WEST SUSSEX COUNTY COUNCIL CONSULTATION

TO:	Arun District Council FAO: Steve Davis
FROM:	WSCC Highways - Public Rights of Way
DATE:	11 June 2026
LOCATION:	Land North of Summer Lane, Pagham
SUBJECT:	P/31/26/OUT Outline application with some matters reserved, except access, for up to 130 No residential dwellings including means of access into the site (not internal roads). This application is a Departure from the Development and affects a Public Right of Way. Amendment to the above application dated 26th May 2026 relating to:- Response Letter and updated TA
DATE OF SITE VISIT:	n/a
RELEVANT PUBLIC RIGHTS OF WAY NUMBER(S):	Footpath 100
RECOMMENDATION:	Objection
S106 CONTRIBUTION TOTAL:	n/a

VEHICULAR ACCESS ACROSS
SUMMER LANE

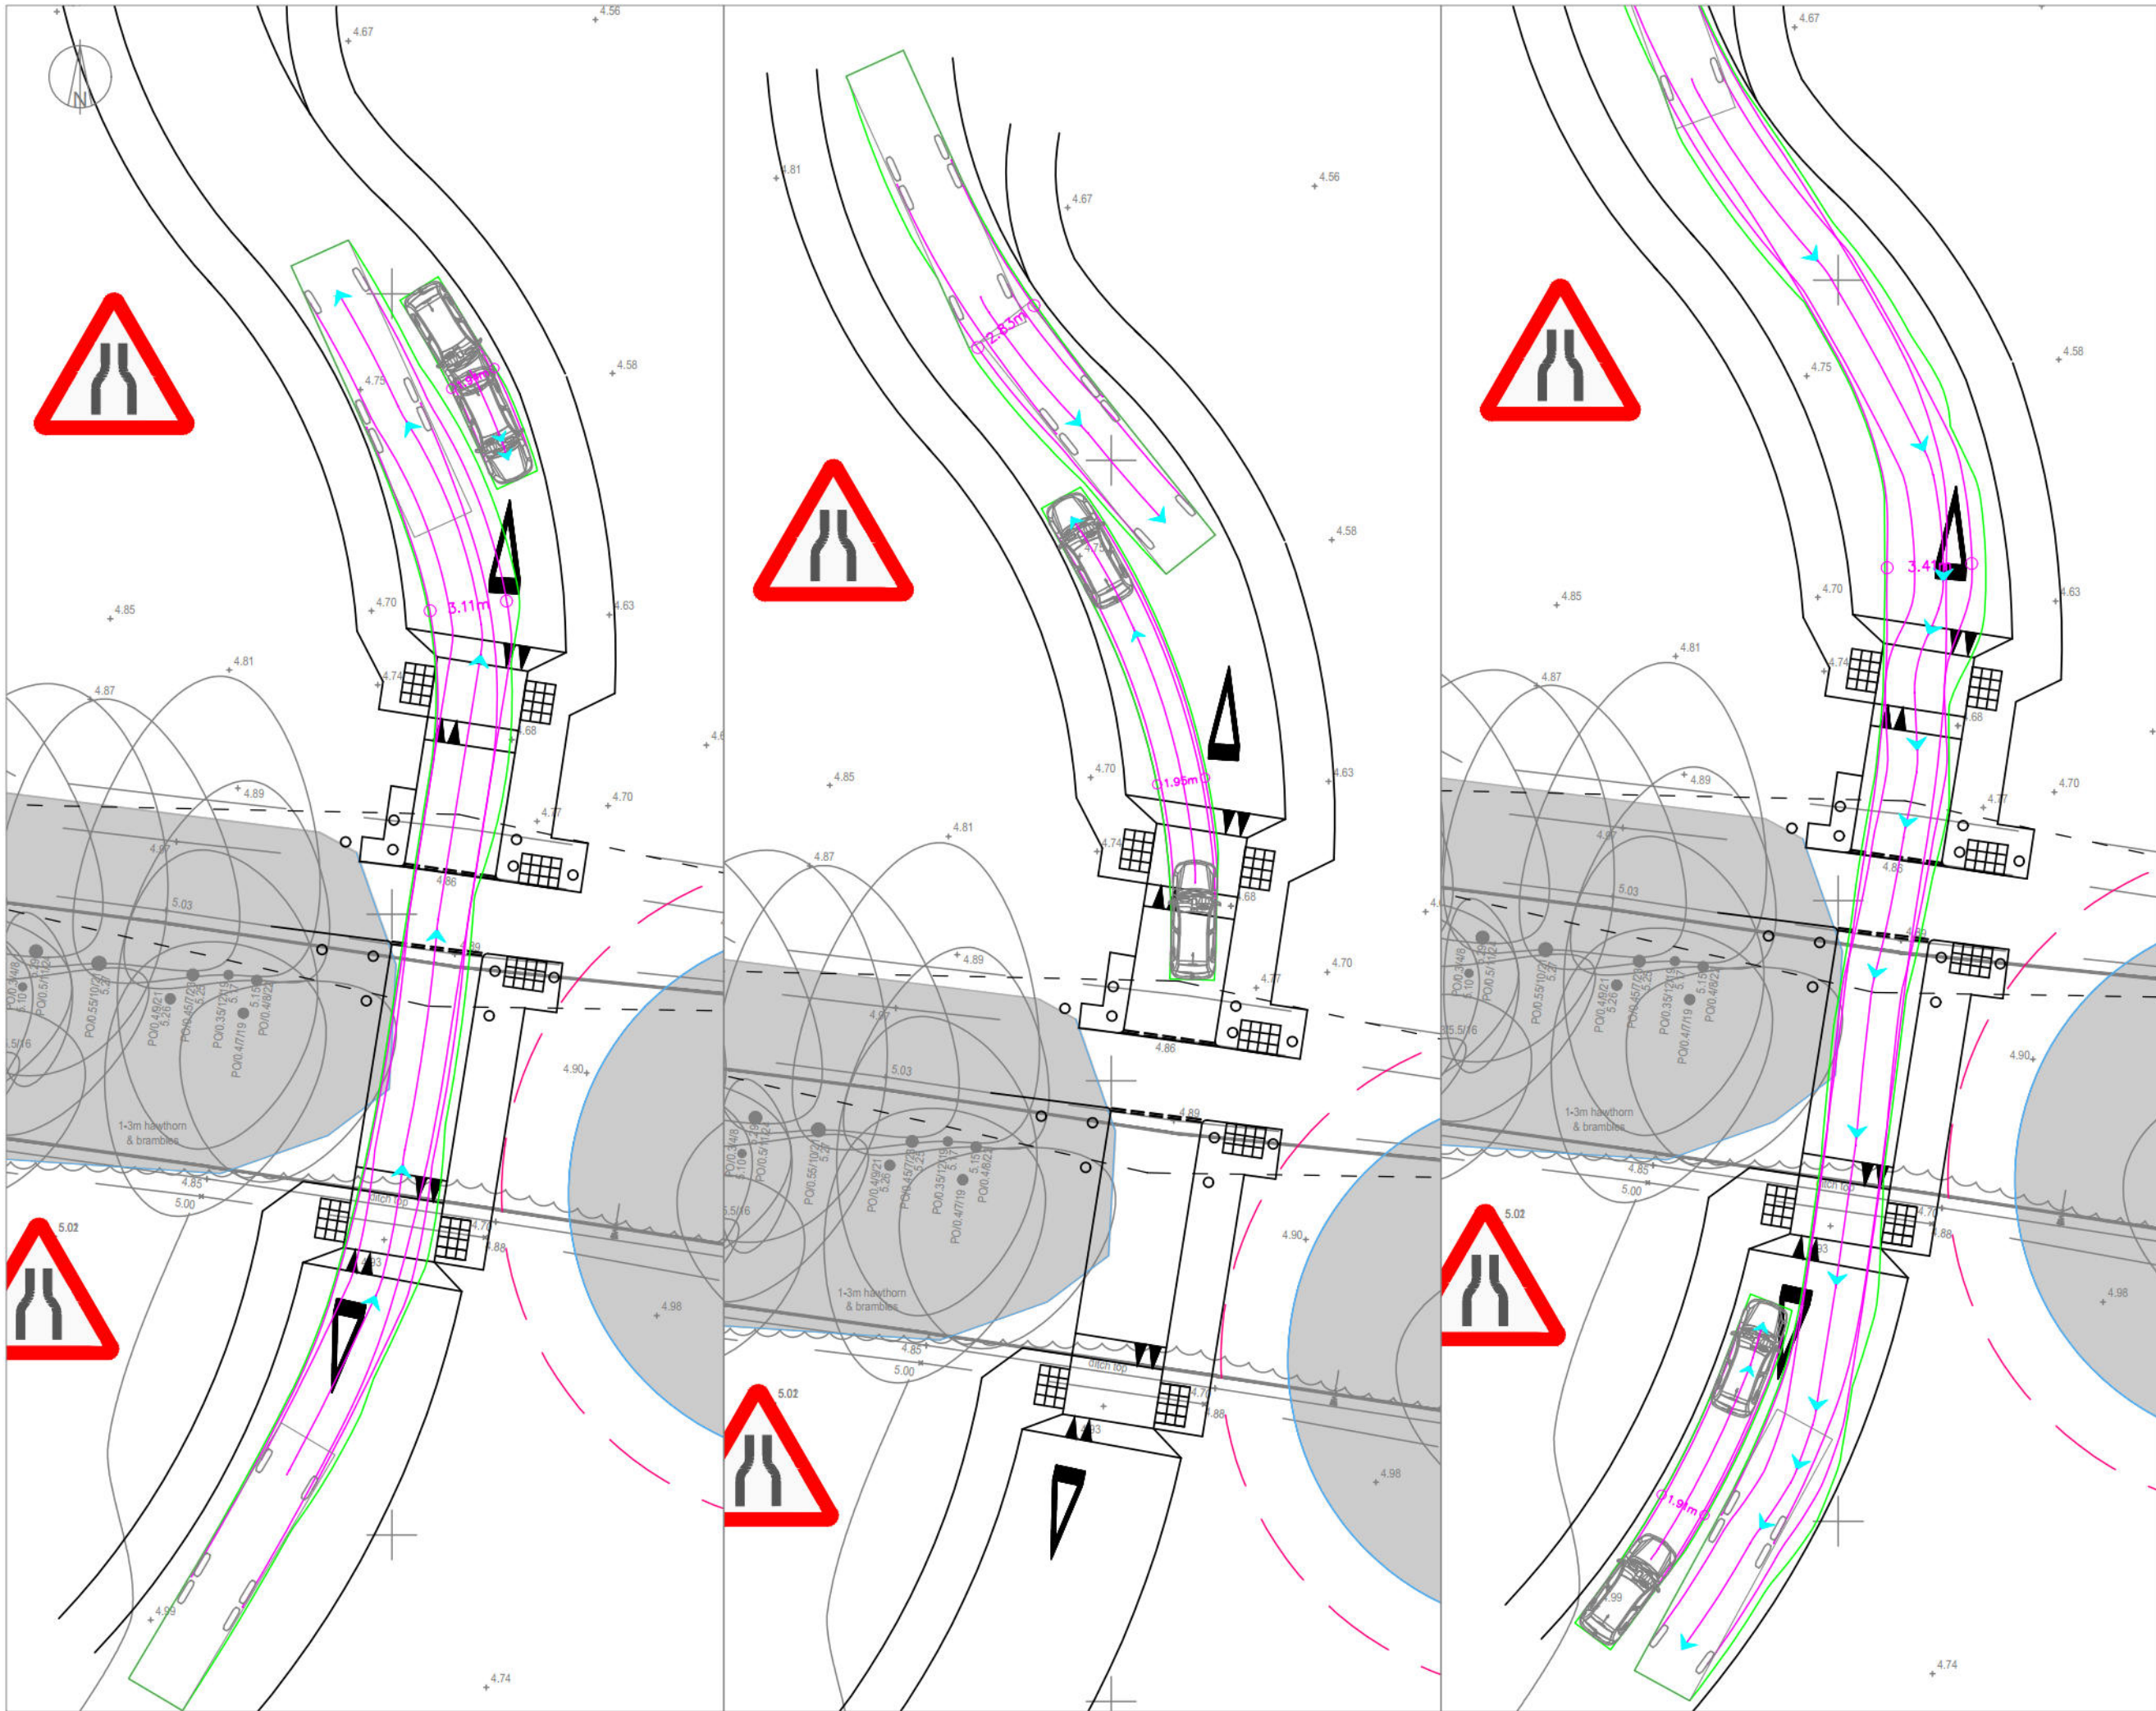
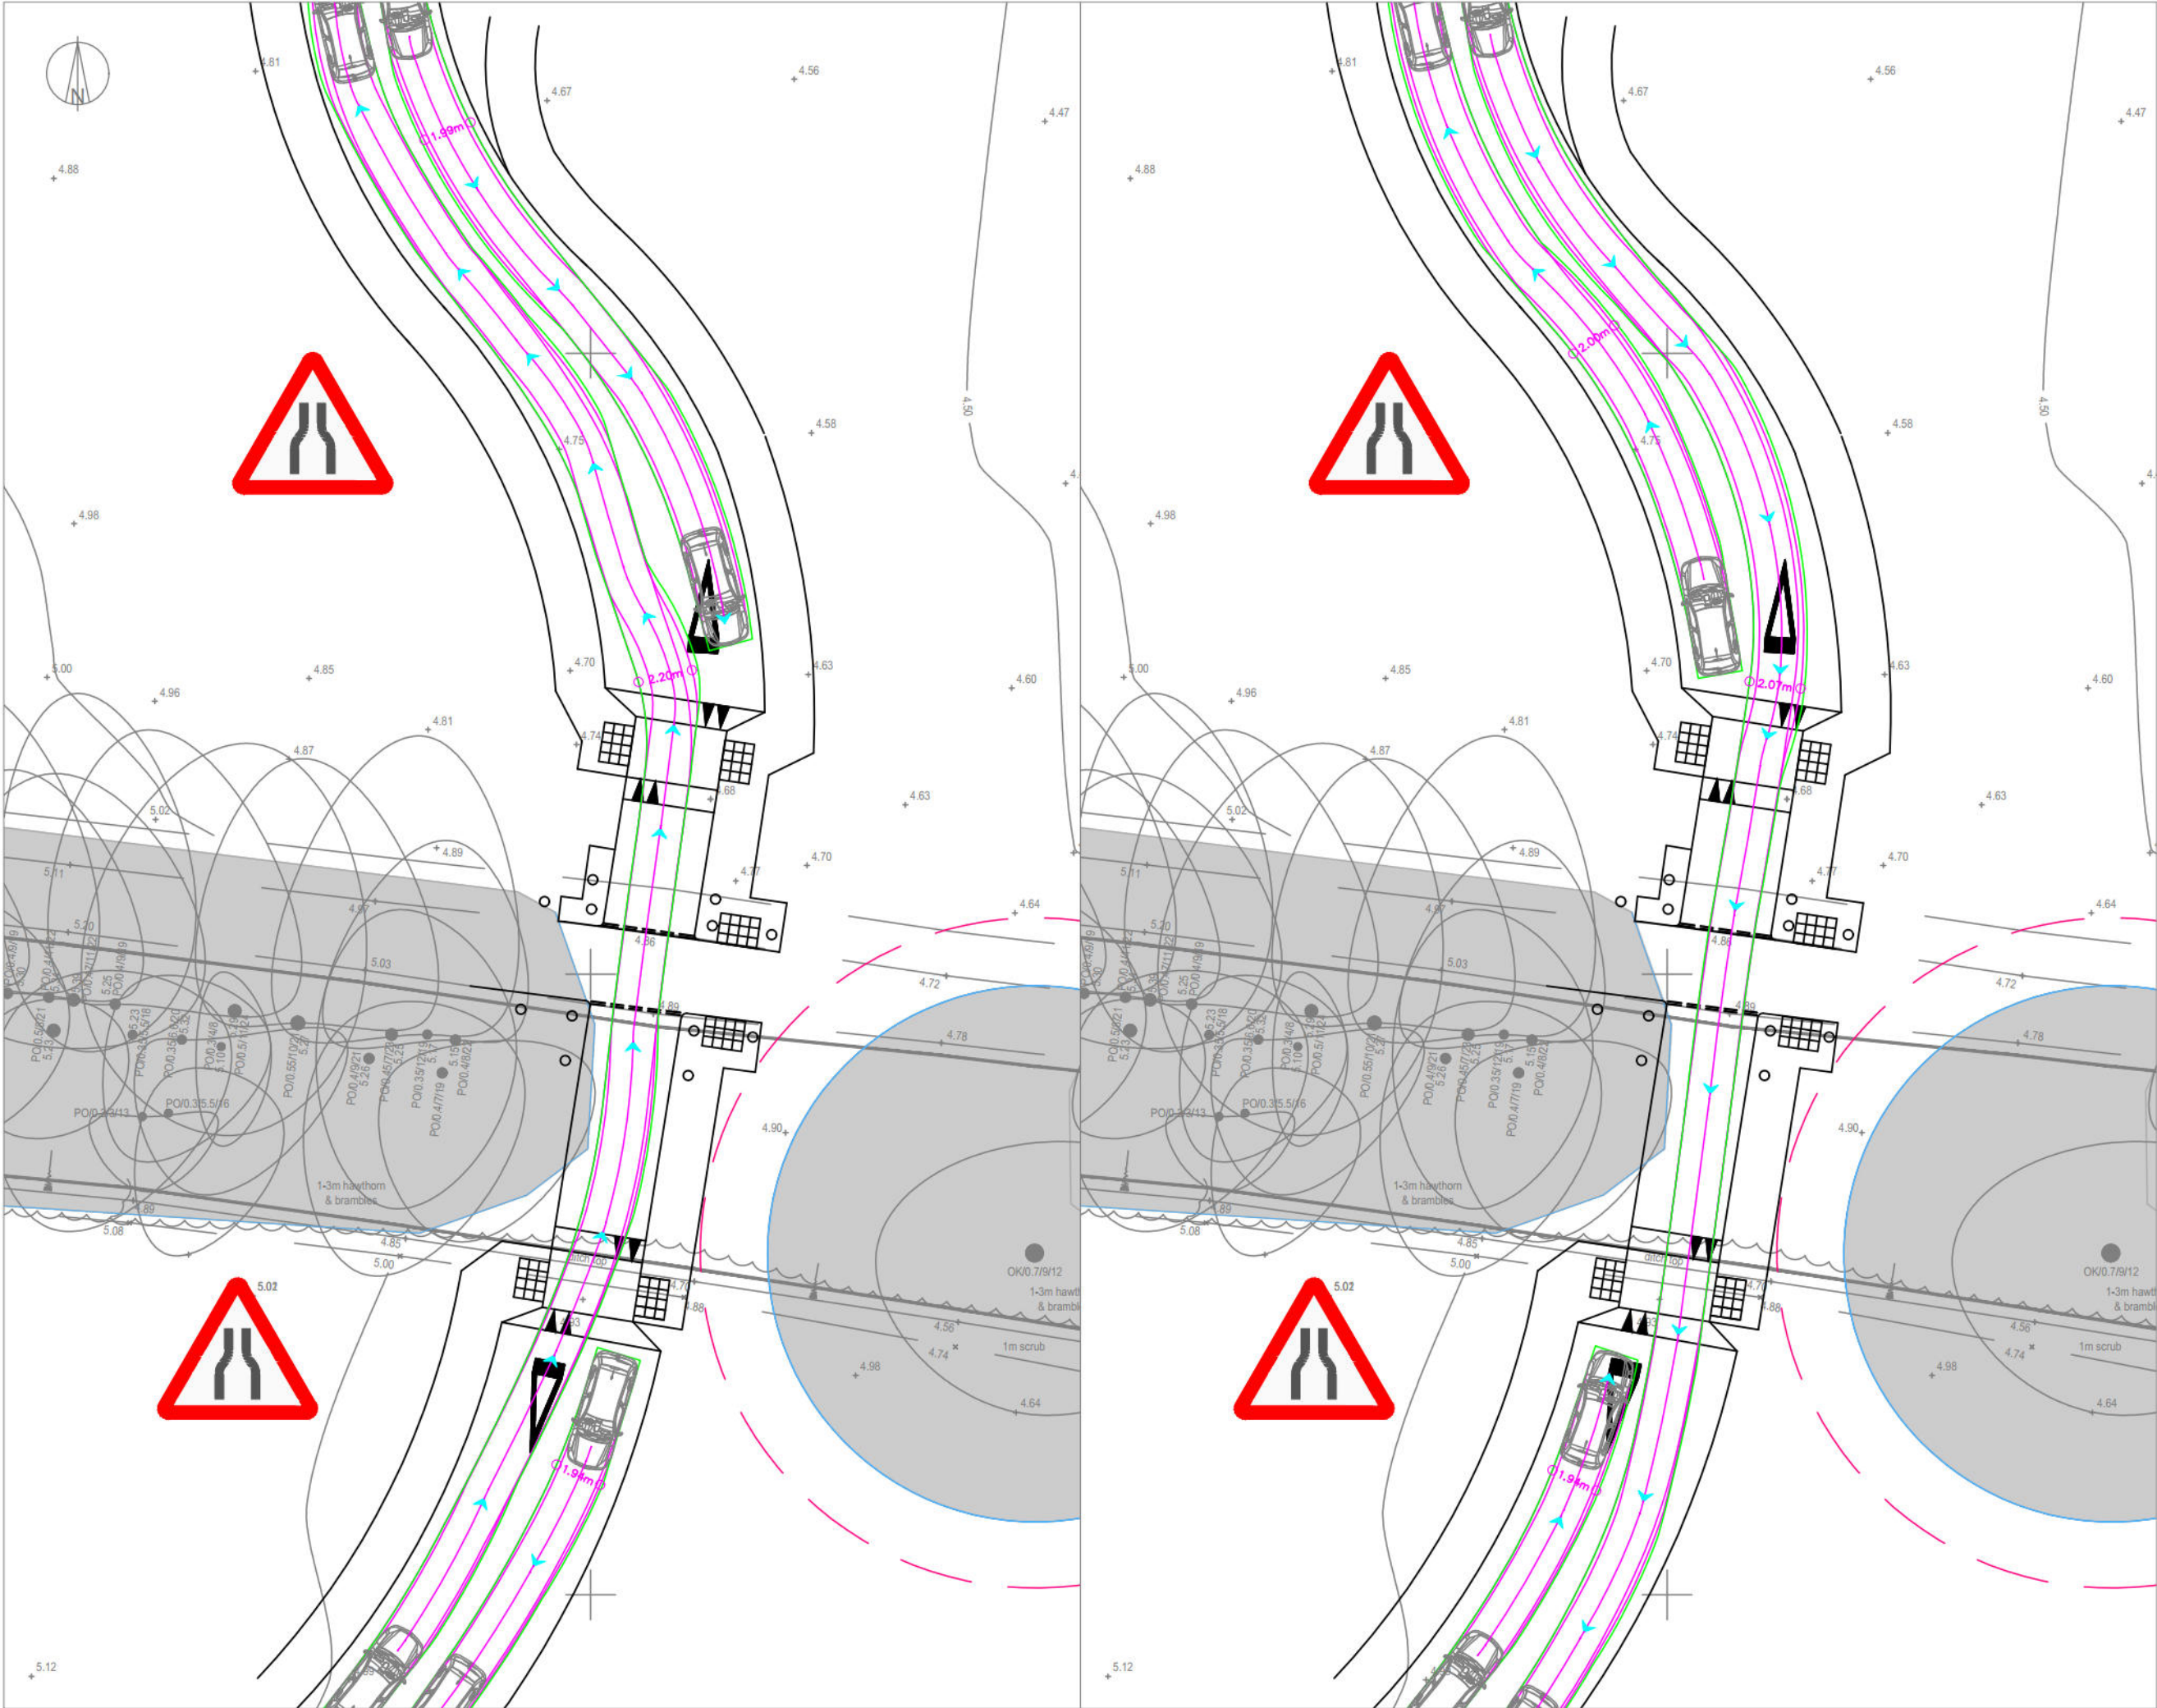
- the PRoW team's maintenance liability will be limited to that of footpath / bridleway users. All damage caused by any other use will remain the responsibility of the landowner.
- the safety of PRoW users takes precedence over that of vehicular users. At the 'straight across' access over Summer Lane, the planned width restrictions, prohibited right or left turn, raised tables and signage are welcomed.

- The area must be well lit and have good visibility. Lighting should be conditioned and dealt with by a reserved matters application.
- The planned bollards or any other structure should not be installed within Summer Lane without consent, the full width of which is PRow. My objection is solely on the planned installation of bollards.
